A303 Sparkford to Ilchester Dualling Scheme TR010036

8.8 Draft Statement of Common Ground with Defence Infrastructure Organisation

STATEMENT OF COMMON GROUND

Version	Date	Status of Version
Rev A	January 2019	Draft for Deadline 2

Drawing Title  
**FIGURE 2.9  
LOCATIONS OF TEMPORARY WORKS AREAS REQUIRED  
DURING CONSTRUCTION - SHEET 2 OF 4**

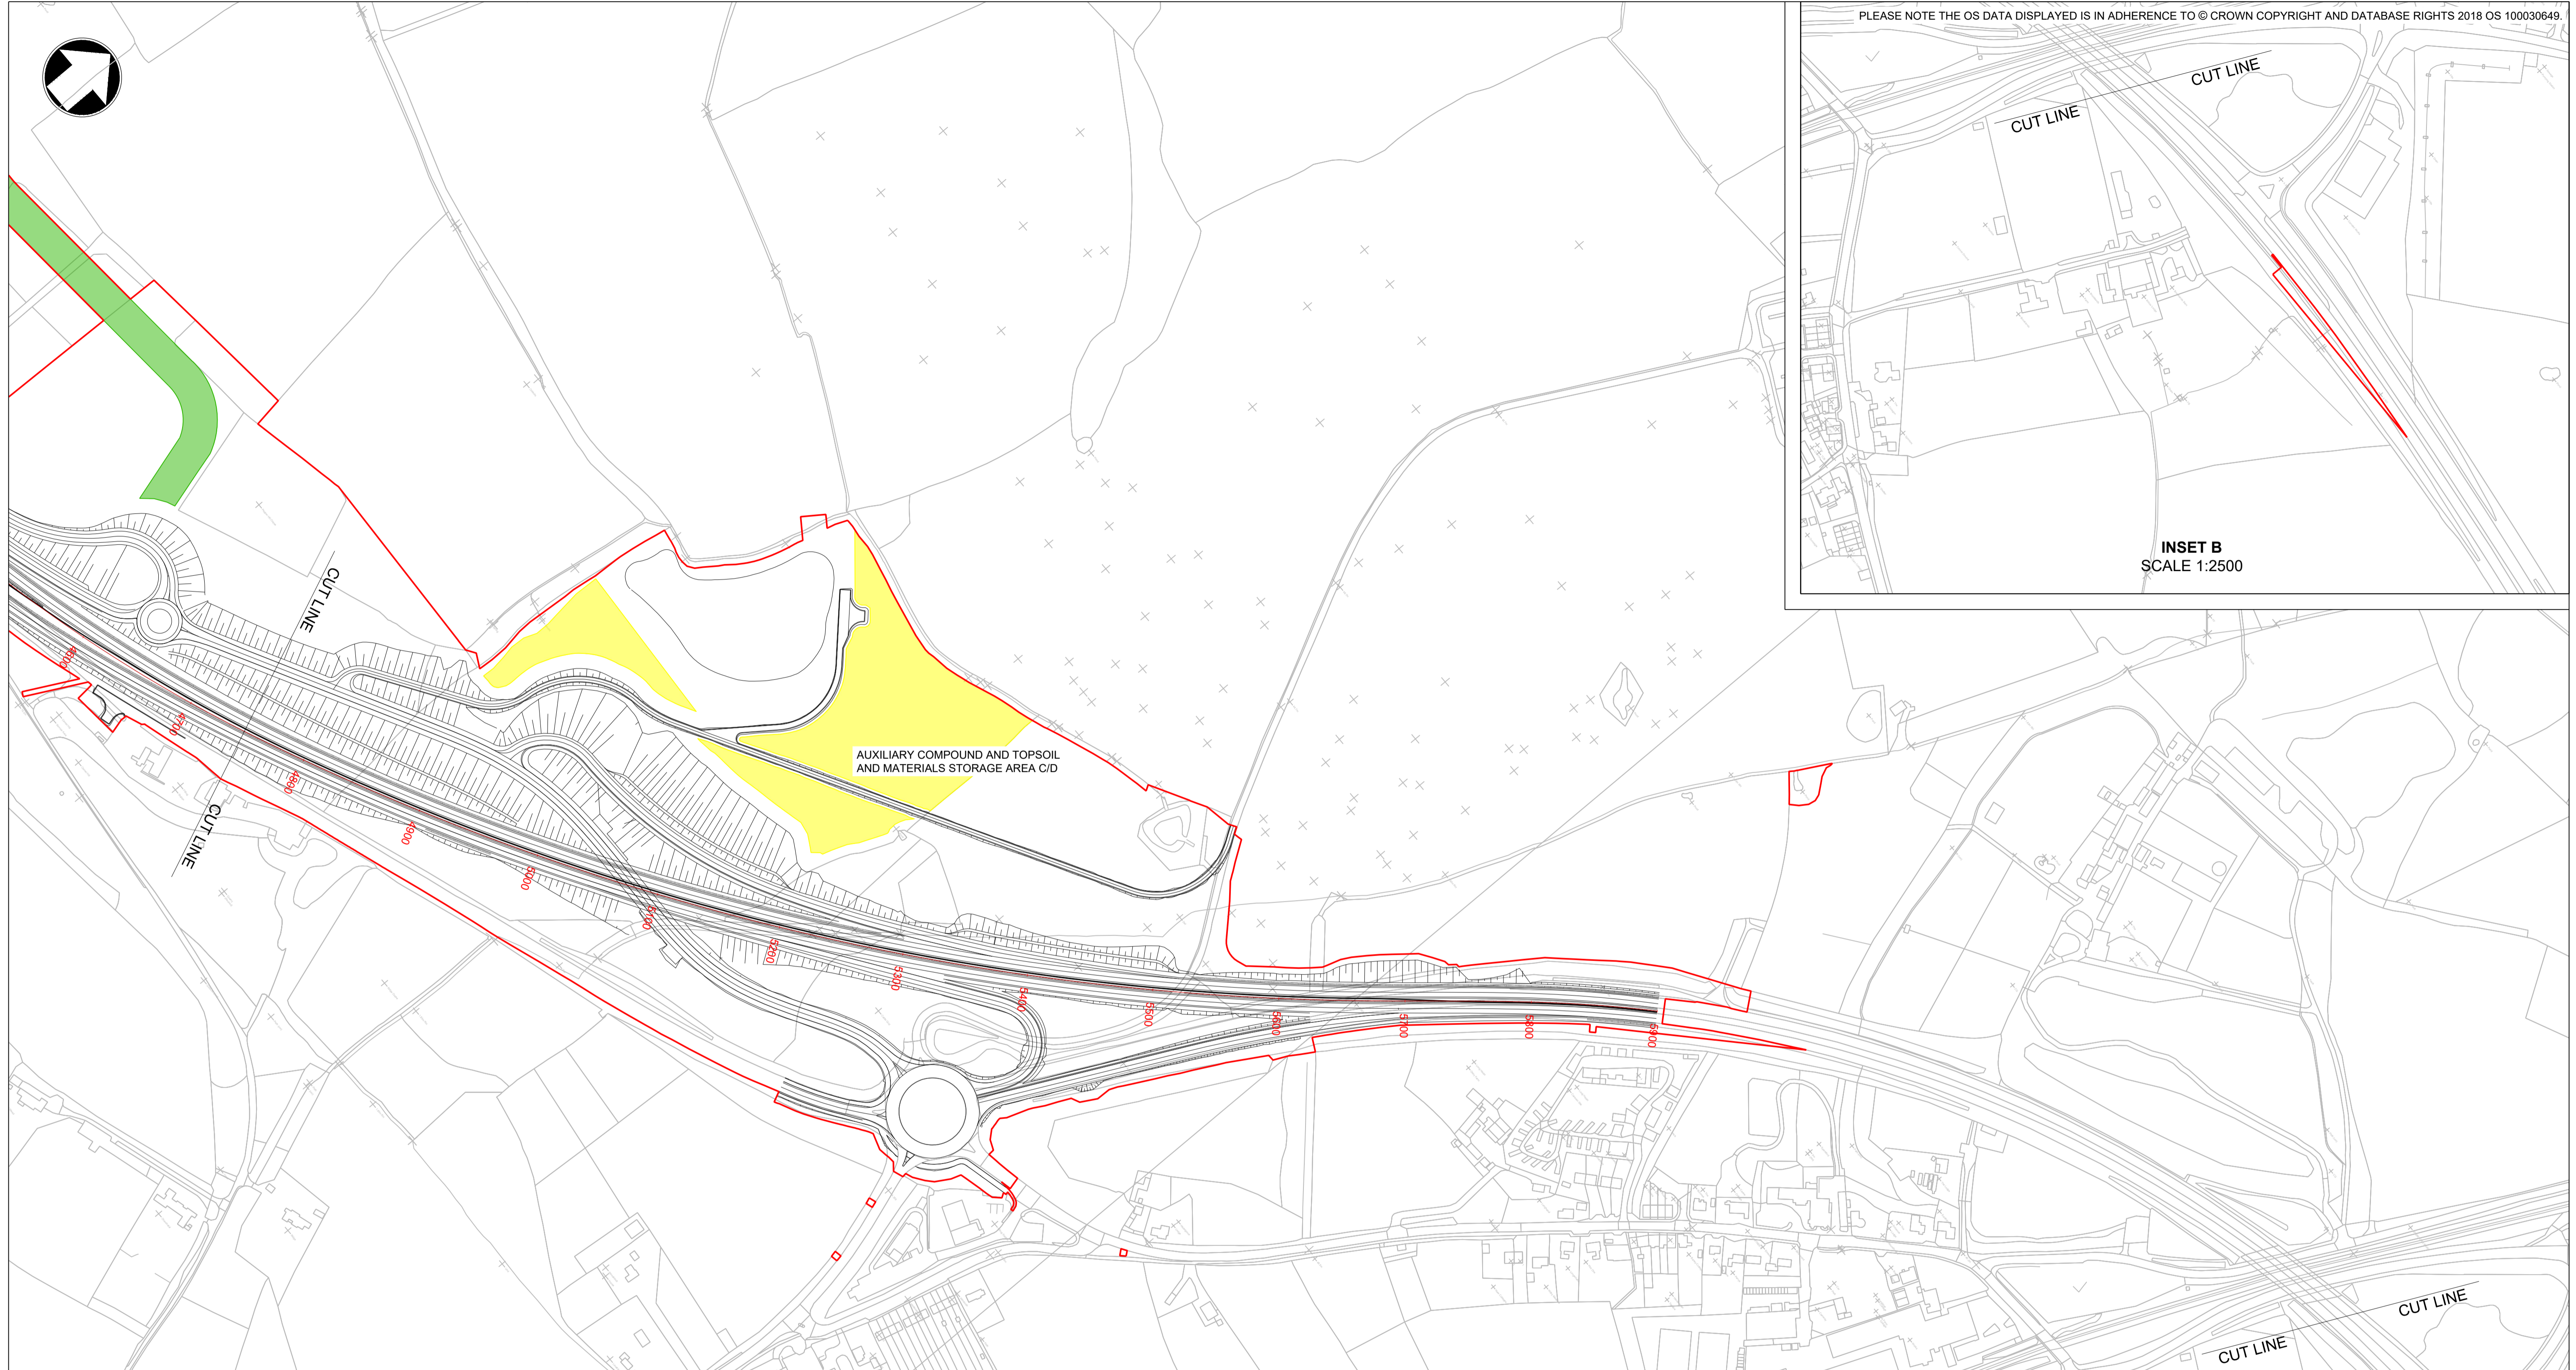
Access	Access to Camel Hill Signal Station	The DIO accept the proposed amendments to the access arrangements to this site	HE Acknowledged.	AGREED
Construction	Main site compound	The main site compound lies in the location for which new landing lights have been proposed. Potential for construction activities to interfere with these landing lights.	Highways England intend to submit a request to the Examining Authority to move the main site compound.	UNDER DISCUSSION

PONDS

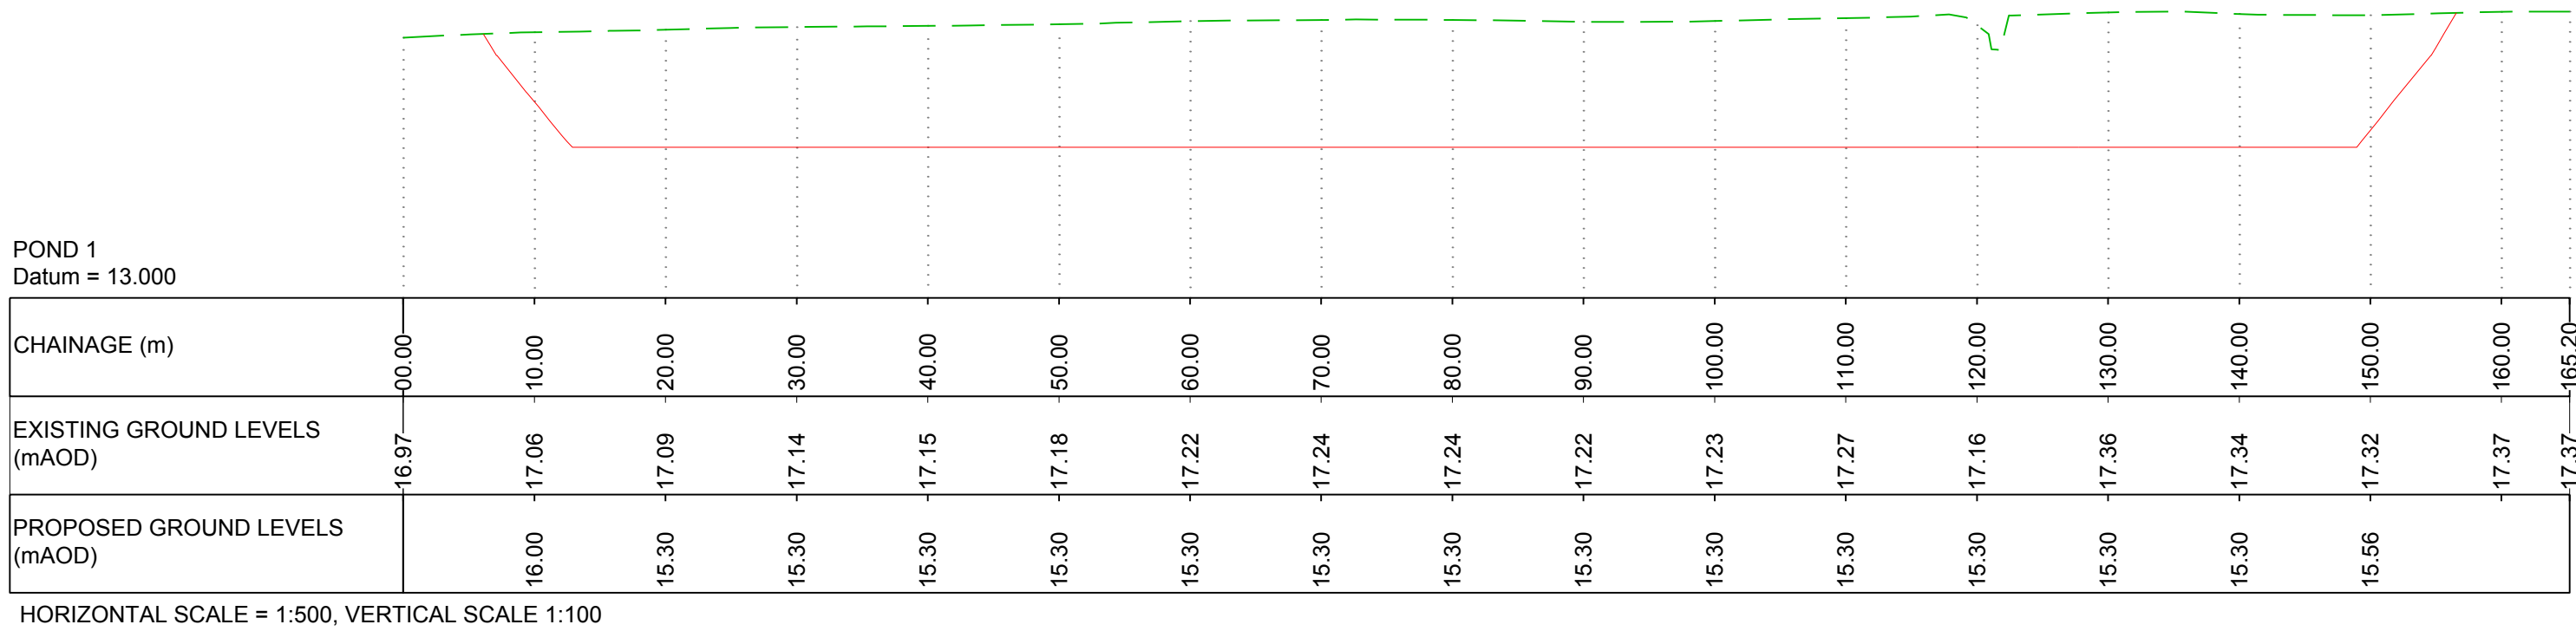
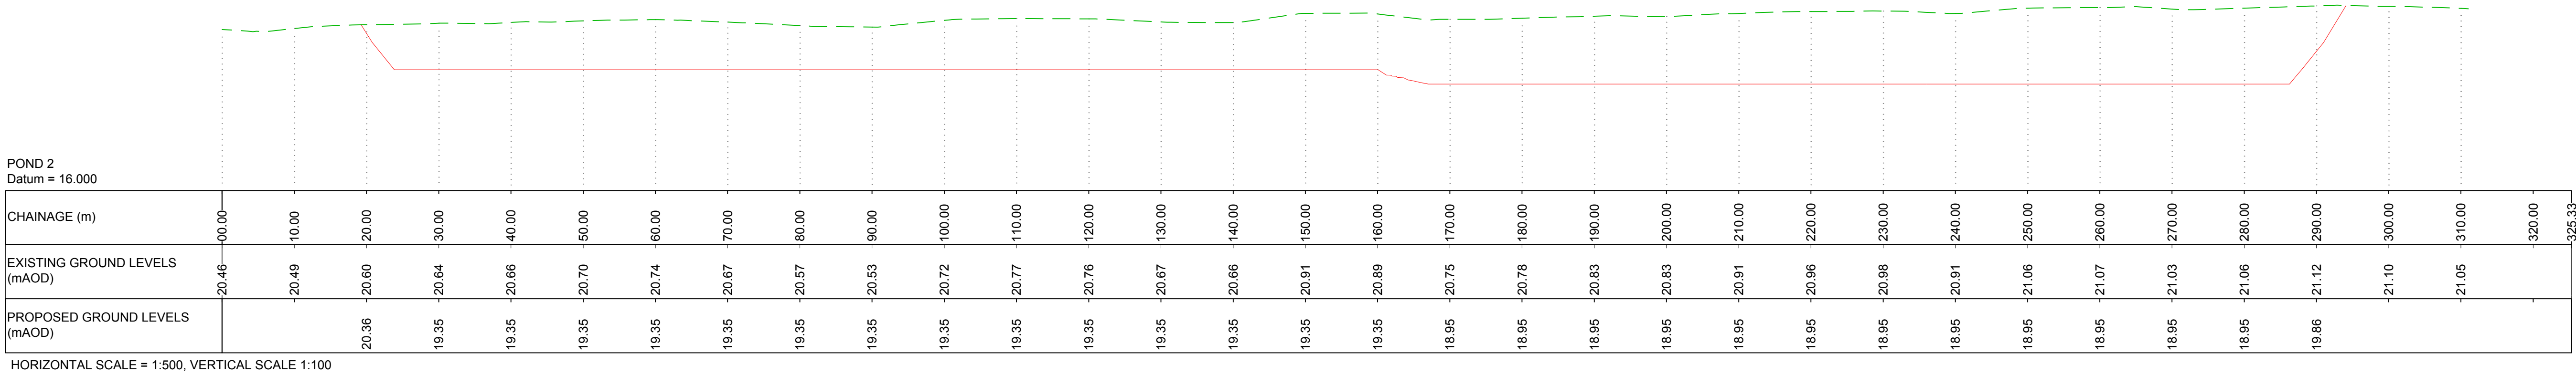
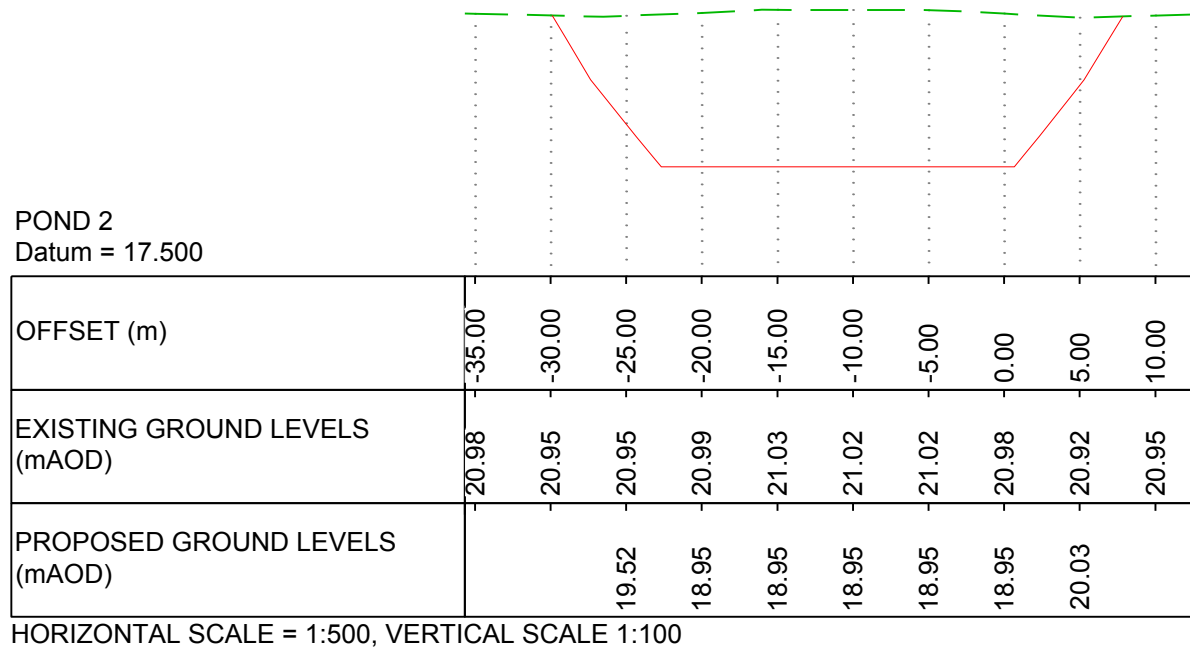
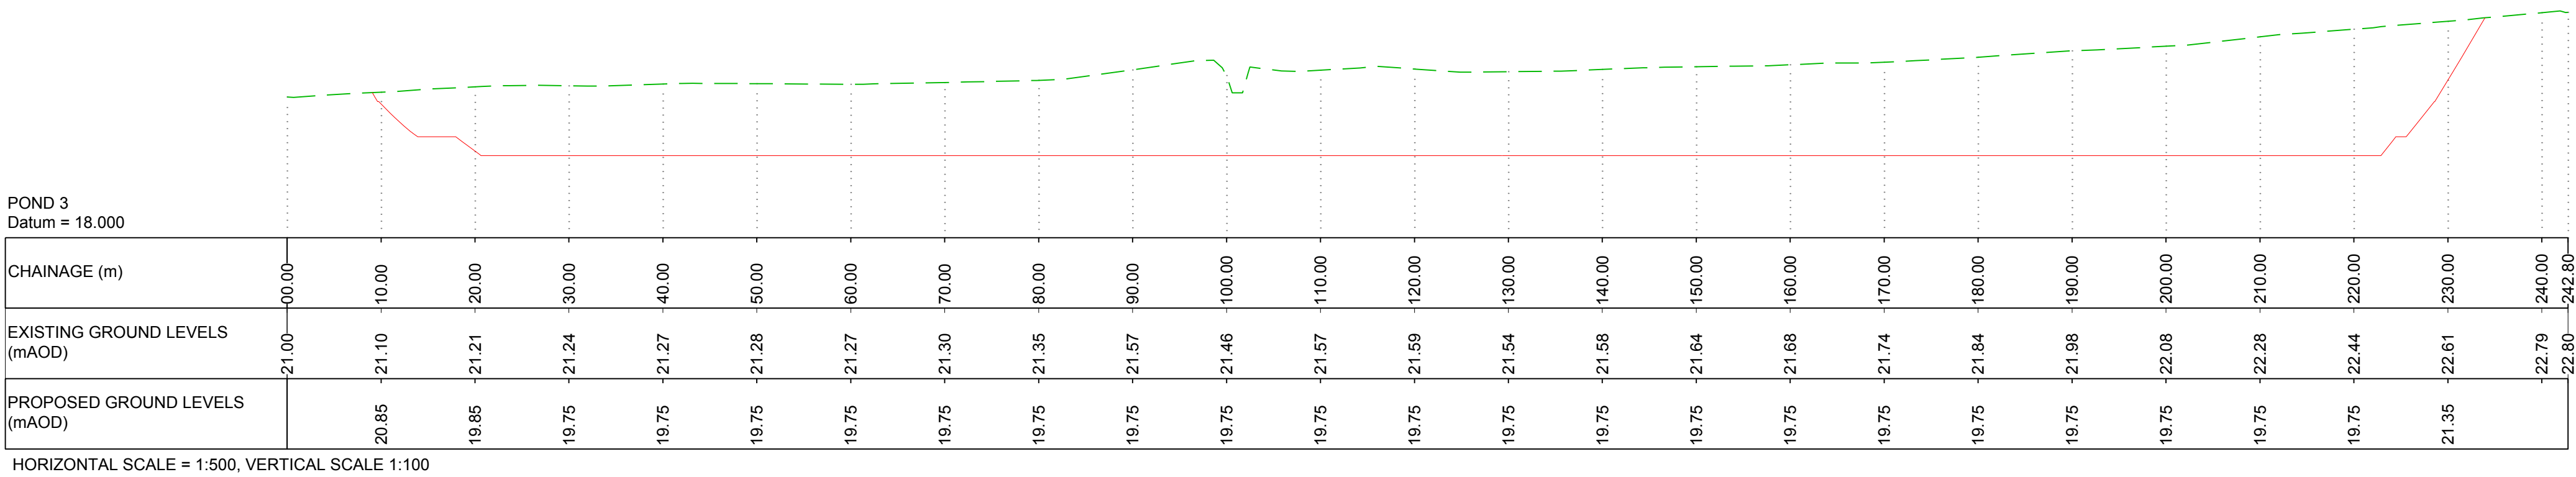
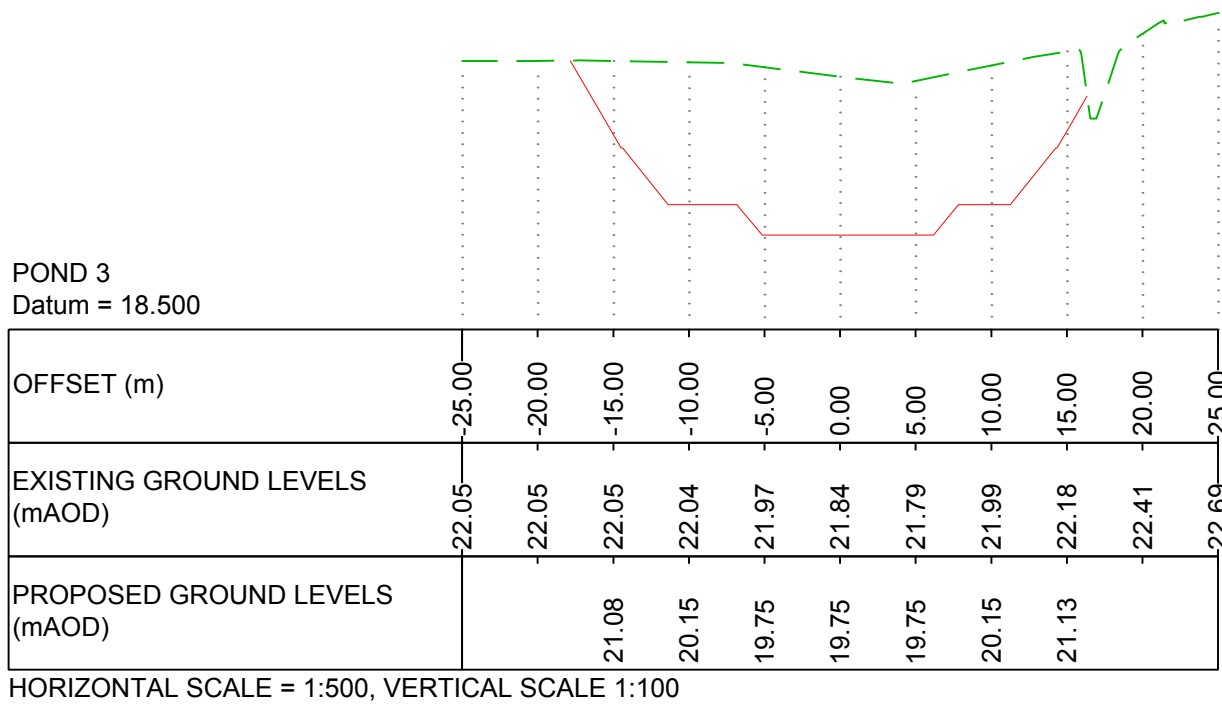
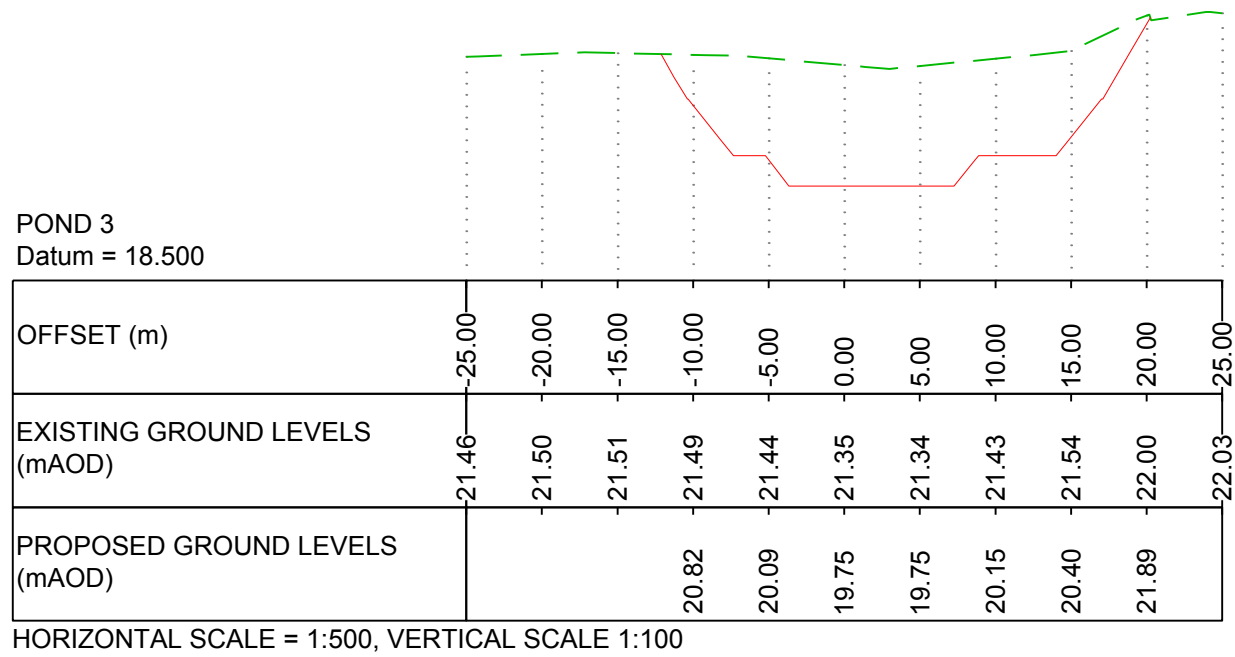
- 3.1.1 The Defence Infrastructure Organisation (DIO) is concerned that the proposal to construct six ponds which will contain permanent bodies of water could attract birds to the area and increase the risk of bird-strikes.
- 3.1.2 An assessment has been undertaken to assess the risk of bird-strikes, which is summarised below.

- 3.3.1 There are six ponds to be constructed as part of the proposed scheme. The risk factor for each pond had been identified based on size, depth and surrounding habitat, that are shown in the table 3.

Pond No.	Plan Area of Permanent Water (m ²)	Depth of Permanent Water (m)**	Surrounding habitat ***	Overall risk
1	1250	0.4	Sheltered by existing vegetation to the north and a proposed hedgerow to the south	Low risk.
2	2650	0.4	Sheltered by proposed hedgerow to the north; proposed A303 carriageway to the south	Low risk.
3	2720	0.4	Sheltered by proposed A303 carriageway to the north; proposed trees, shrubs and hedgerow to the south	Low risk.
4	680	0.4	Existing trees and shrubs to the north; proposed grassland and arable land to the south	Medium risk – with additional planting, this can be reduced to low risk.
5	4610	0.4	Existing trees and shrubs to the north and west; proposed wildflower grassland to the south (however open views are not possible due to the proposed A303 to the south of this)	Low risk.
6	160	This is the proposed wildlife pond – no depth has yet been specified. Would be beneficial for GCN as well as reducing bird strike for it to be fairly shallow.	Existing trees and shrubs to the north; proposed wildflower grassland to the south (however open views are not possible due to the proposed A303 to the south of this)	Low risk.

- There are limited records of problem bird species in the area;
- Ponds are generally sheltered apart from pond 4, which may require some additional measures.
- Adjacent road noise is likely to deter birds; and
- There will be no public access to these ponds to eliminate possible bird feeding.

- The planting adjacent to Pond 4 will be reviewed.
- Further discussion with the DIO's bird-strike safeguarding team would be useful.
